RE: Responses to Comments – Technical Review 2  
White Barn – Chick-Fil-A  
Highway 9 and Soper Hill Road, Marysville, Washington 98258  
Permit No. PA23-019 / Our Job No. 22579

We have revised the plans and technical documents for the above-referenced project in accordance with your comments dated May 3, 2024. The following outline provides each of your comments in italics exactly as written, along with a narrative response describing how each comment was addressed:

SECTION VIEW
SCALE: N.T.S.

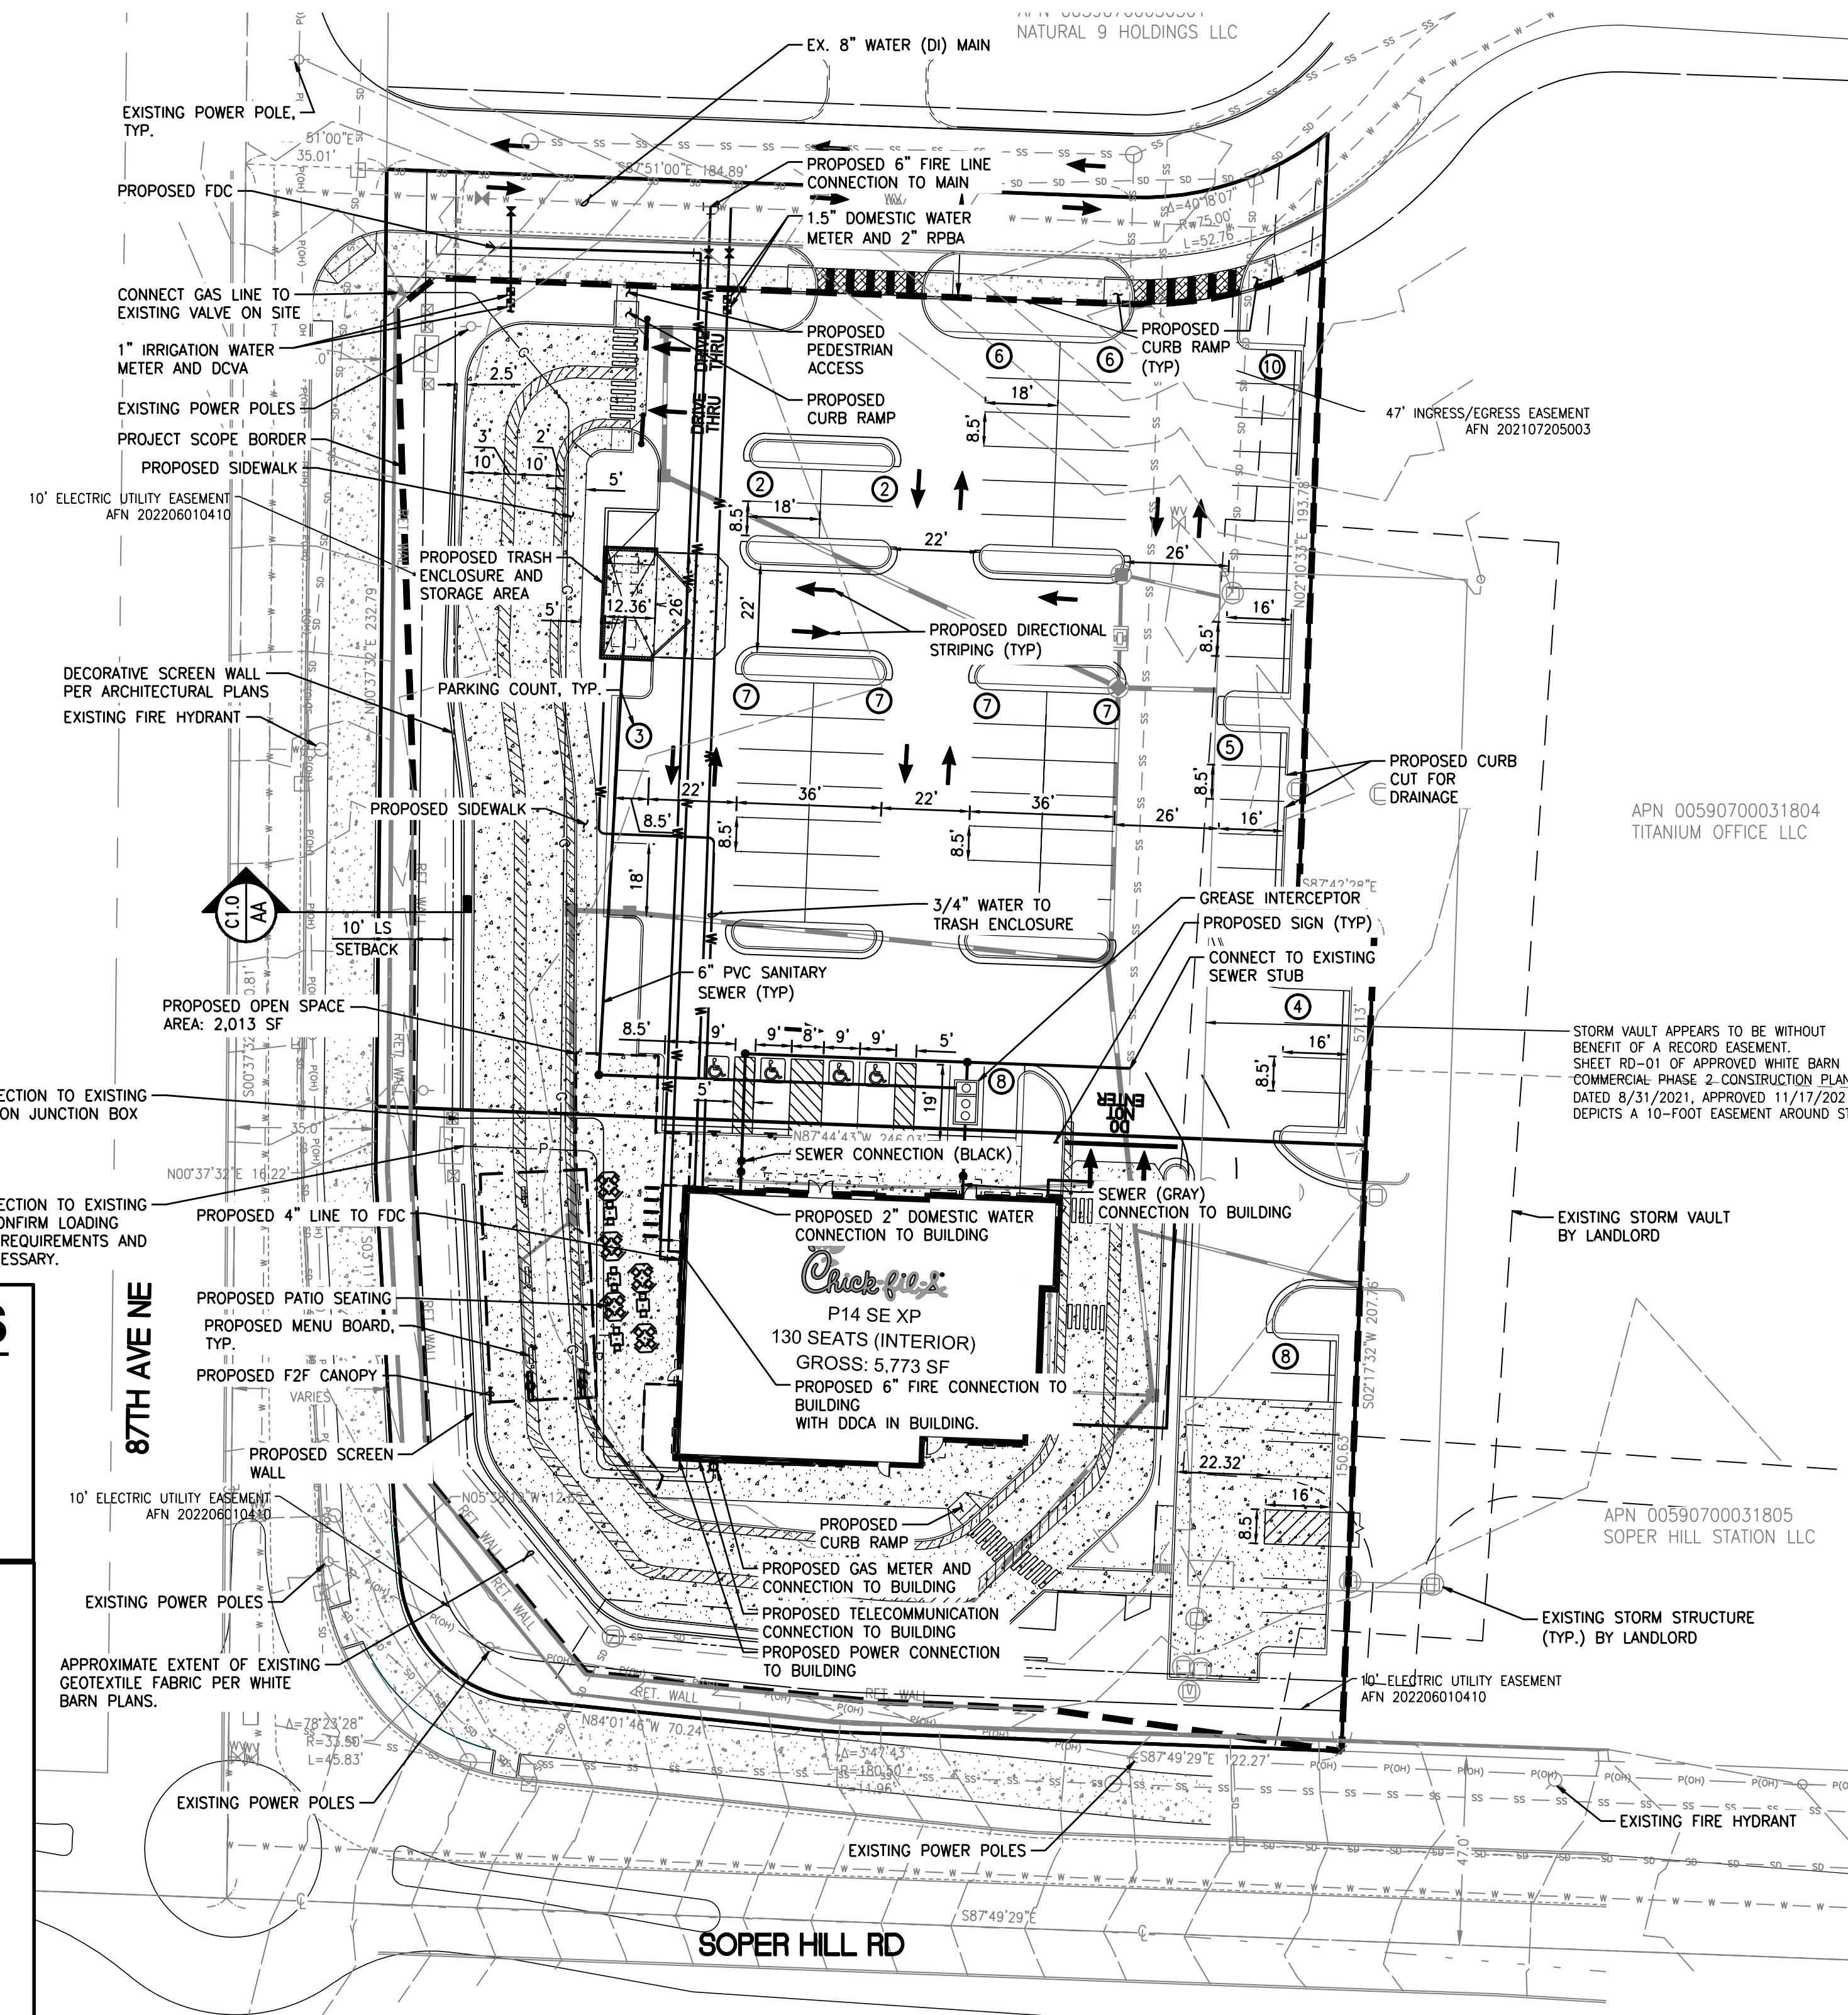
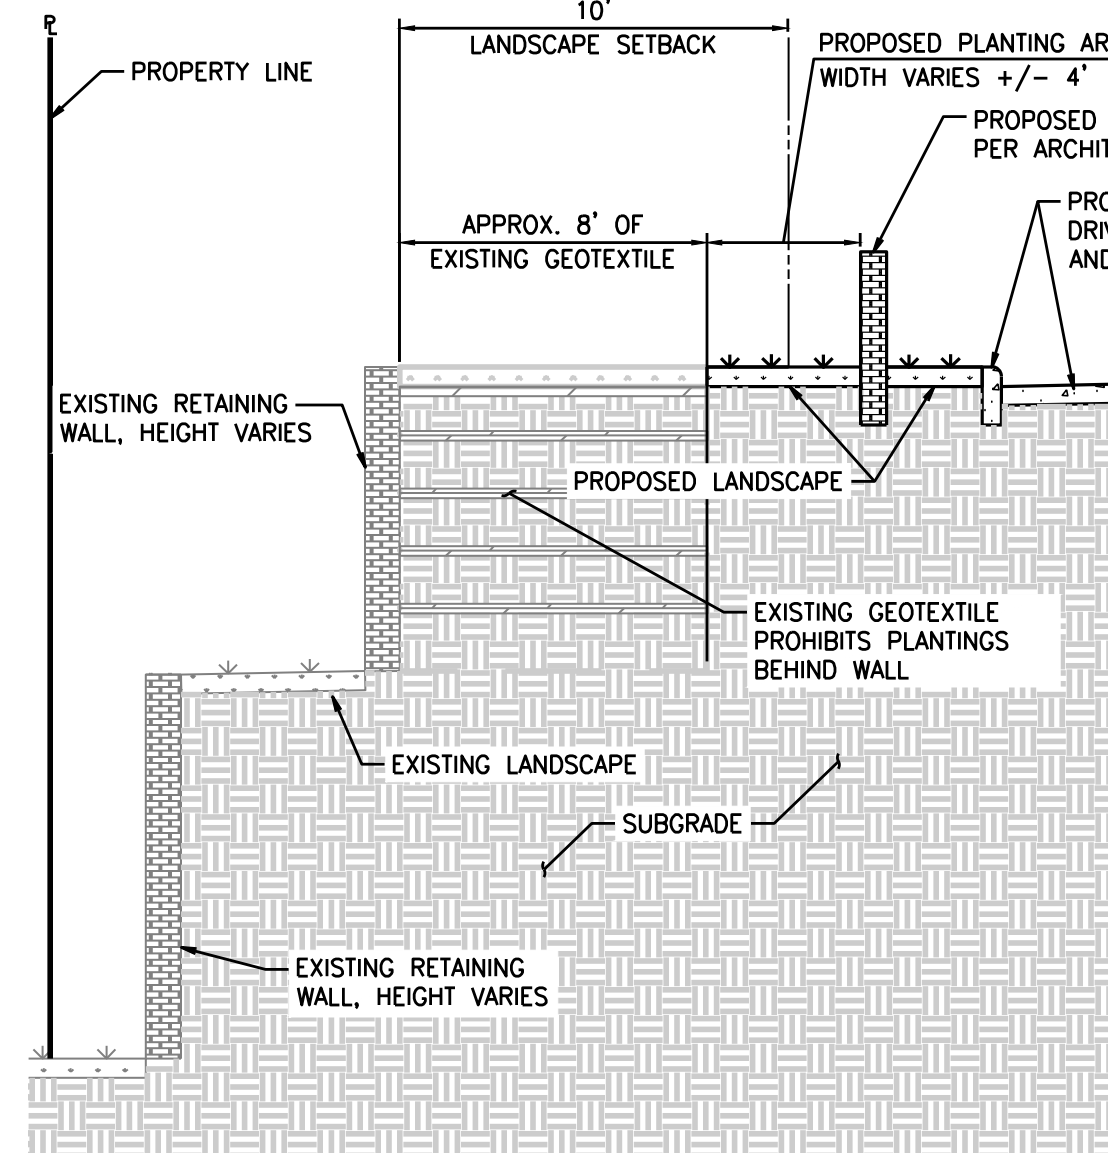
1. *As stated in the TR1 comments a minimum 30' L3 landscape buffer is required along Soper Hill Road and 87th Avenue NE. Pursuant to MMC 22C.070.210(2)(iv), the Director may approve and condition reduced planter widths provided the design meets the intent of the standards and guidelines. For example, reduced widths may be allowed provided the landscaped area is supplemented with architectural features that help to define the street edge and maintain visual continuity along the street. Examples could include a decorative low wall made of stone or masonry that is used in conjunction with landscaping, and/or use of a landscaped trellis or architectural columns. For each method, it is important to maintain visibility at eye level (between three and eight feet above the ground) between the street into the parking lot for safety.*

*In the TR1 response memo it states that a 15' L2 landscape buffer has been provided along Soper Hill Road and 87th Avenue NE, however, in review of the revised site and landscape plans it appears only a 3 to 8' landscape buffer and a wall is proposed. In addition the buffer does not comply with the L2 screening standards. The following is the L2 planting standards guidelines:*

*In discussion with the Director, the City is willing to reduce the landscape buffer along Soper Hill Road and 87th Avenue NE to a 10' L2 buffer, with a decorative screen wall that is constructed with materials that are complimentary of the proposed restaurant. Colored architectural drawings and a revised screen wall will need to be submitted for Director approval. At this time it is unclear if the two examples provided would meet this criteria. The Renton, WA example would not be acceptable.*

*In order to accomplish the landscape buffer requirements, the restaurant may need to be relocated to the northeast.*

**Response:** The project has managed to accomplish the buffer requirements by adjusting the location of the drive-through to be positioned 10 feet from the top back of the existing retaining wall along the project frontage. This was completed without adjusting the location of the building. This is demonstrated in the section provided on Sheet C1.0 and on the plan callouts.

The trash enclosure location and interior drive aisles were also adjusted and there was a loss of some parking stalls to accommodate this shift.
